From: [REDACTED]
To: [Hinckley SRFI](#)
Subject: Hinckley National Rail Freight Interchange Response by IP 20038907
Date: 06 February 2025 17:11:36

Interested Party Reference – 20038907

Comments on the TSH response (10 December 2024) to the SoS letter (10 September 2024)

Drawing Title
GENERAL ARRANGEMENT SHEET 18

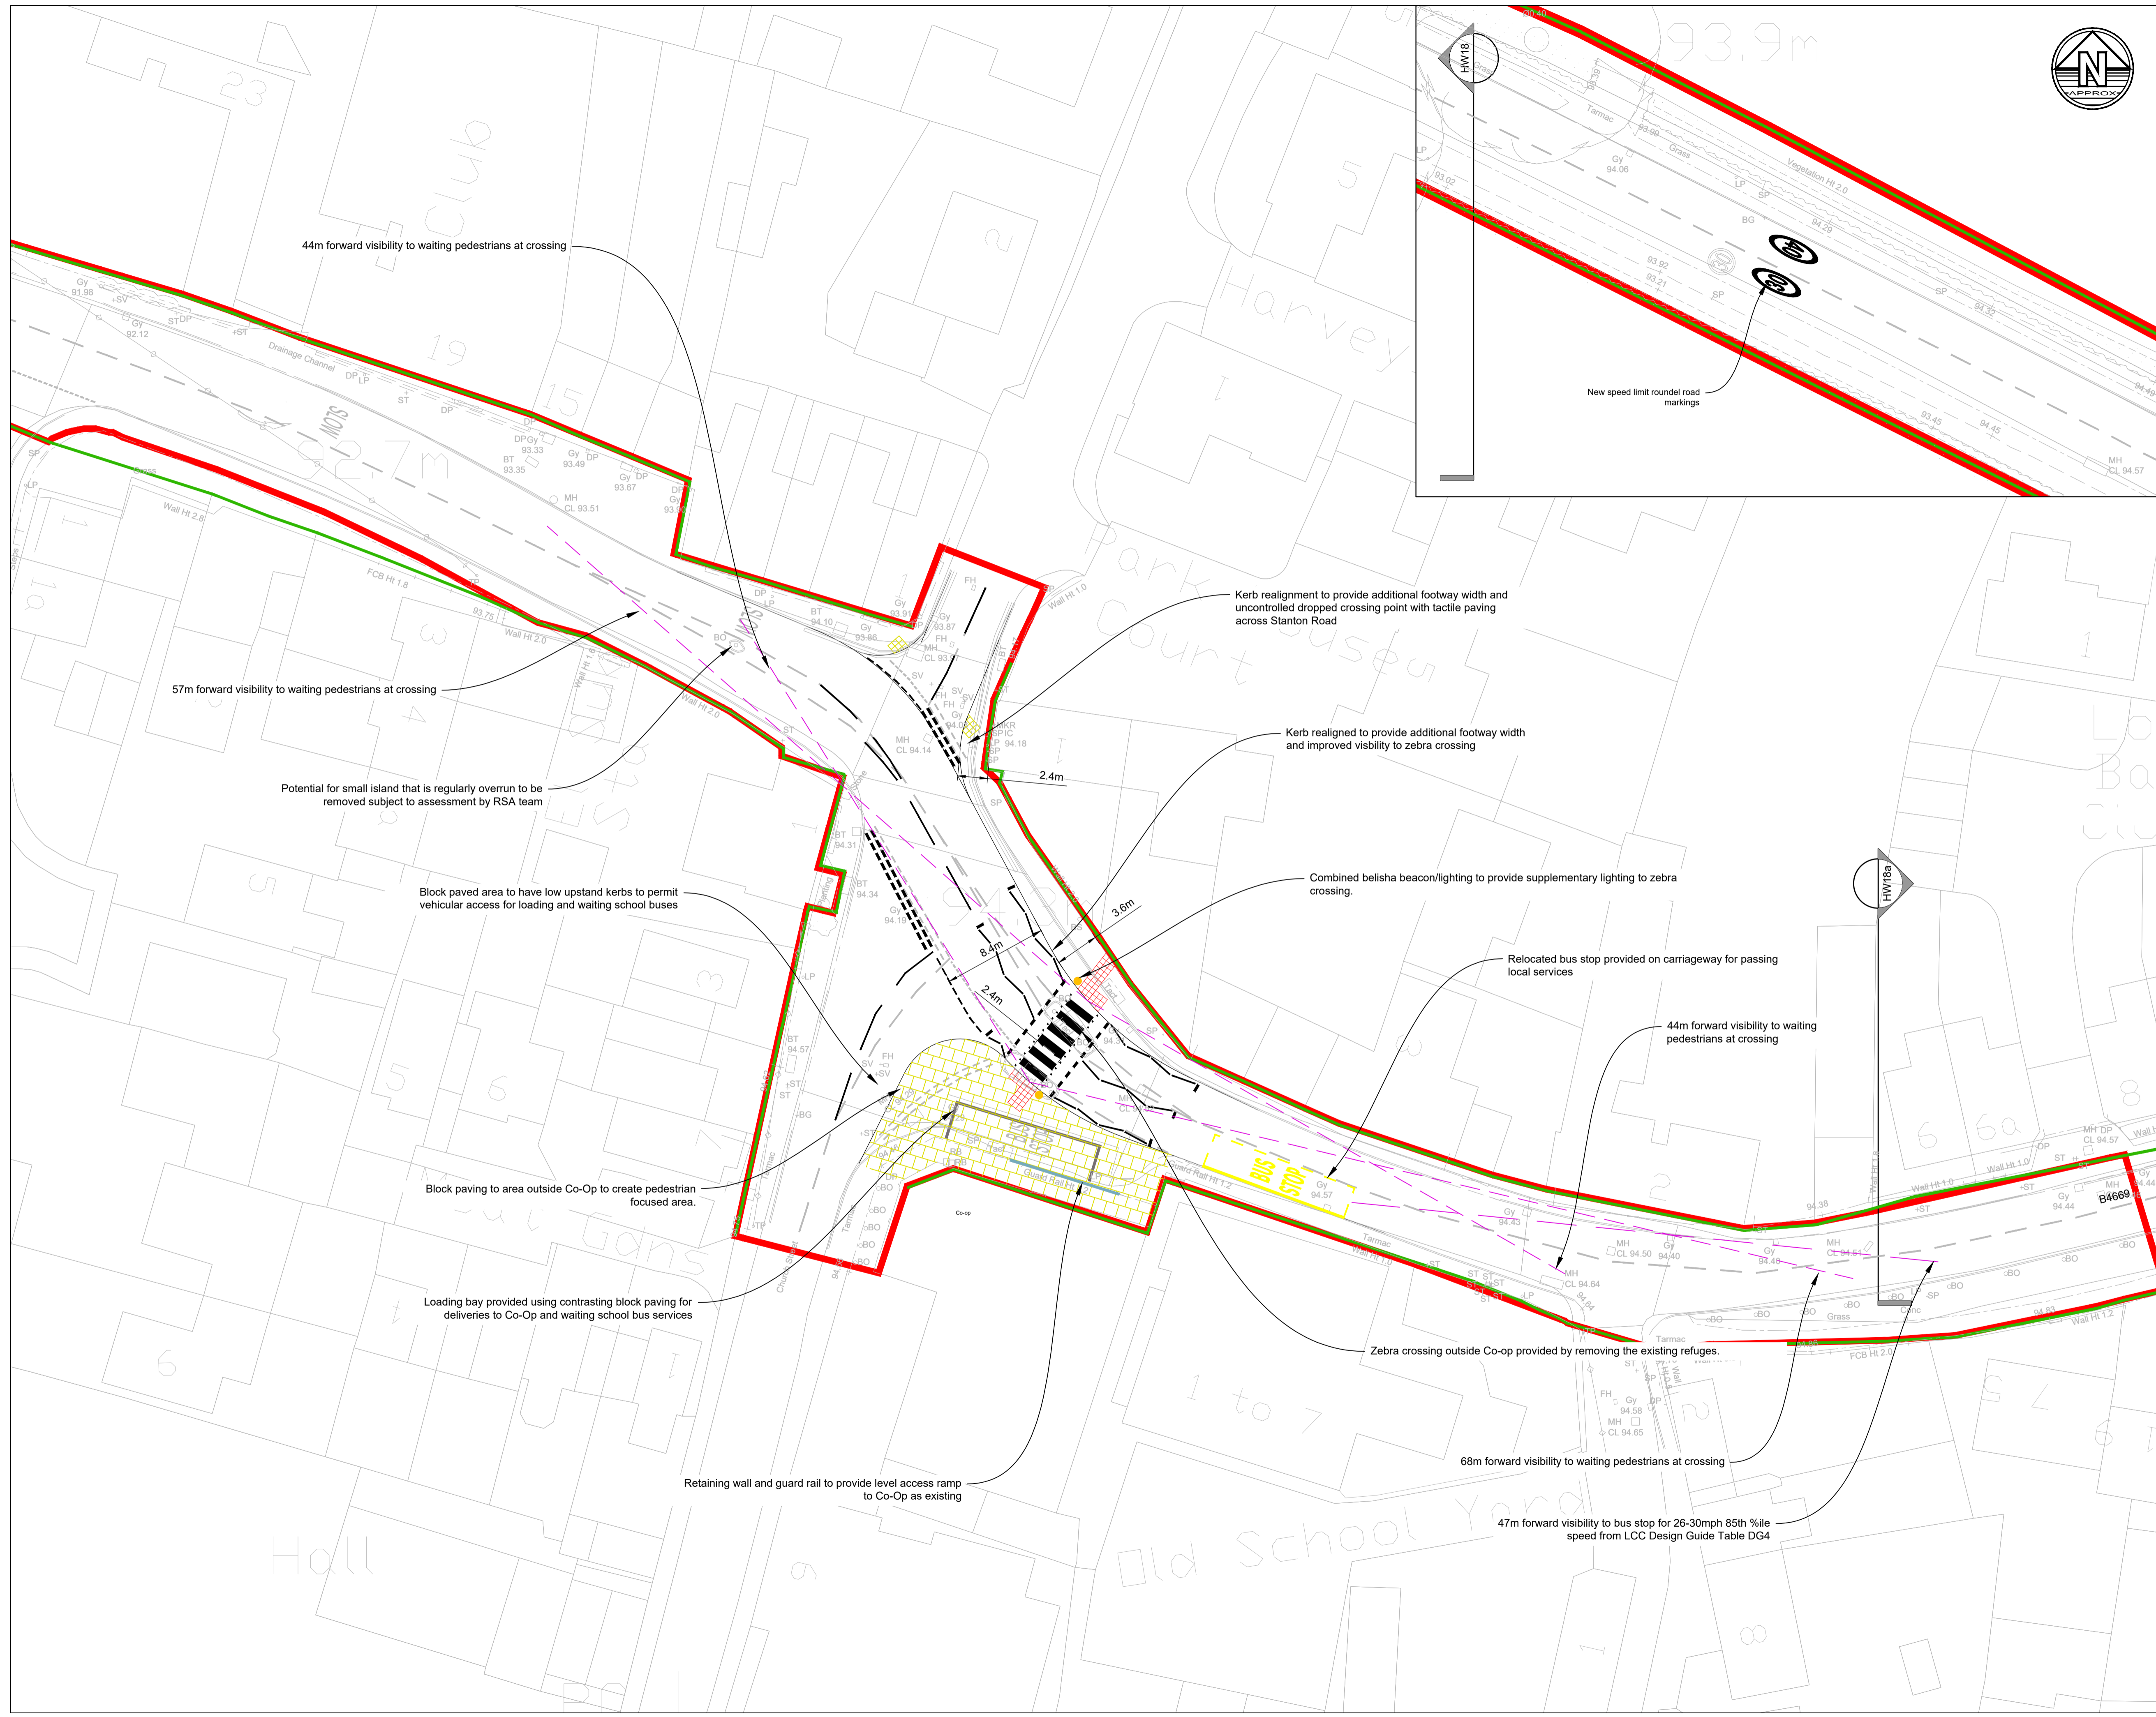
The ExA had gone to great lengths to understand the situation in Sapcote and the Applicant's proposals. The ExA did not agree with the proposals for 'vehicle signage'. The

notion of reducing the width of the road to ensure that only one HGV could get through would inevitably cause more safety problems to a situation that is already an issue. It is a poorly thought out 'solution' as there is no provision for what happens when there are two oncoming vehicles in the narrow part of the road, forcing a vehicle onto the pavement to avoid collision. There is no provision for who would be required to give way.

The proposal to move the bus-stop into a lay-by raises several concerns and no apparent contingencies. For example, if a bus is in the lay-by, it obscures the on-coming traffic warning sign to other vehicles. It is a busy area, with children waiting for school buses, deliveries to the Co-op, residents accessing the shop, parents taking children to and from school, delivery and collection of goods from the parcel drop facility. In proximity there is a day-nursery, a residential home, other businesses, as well as residential properties.
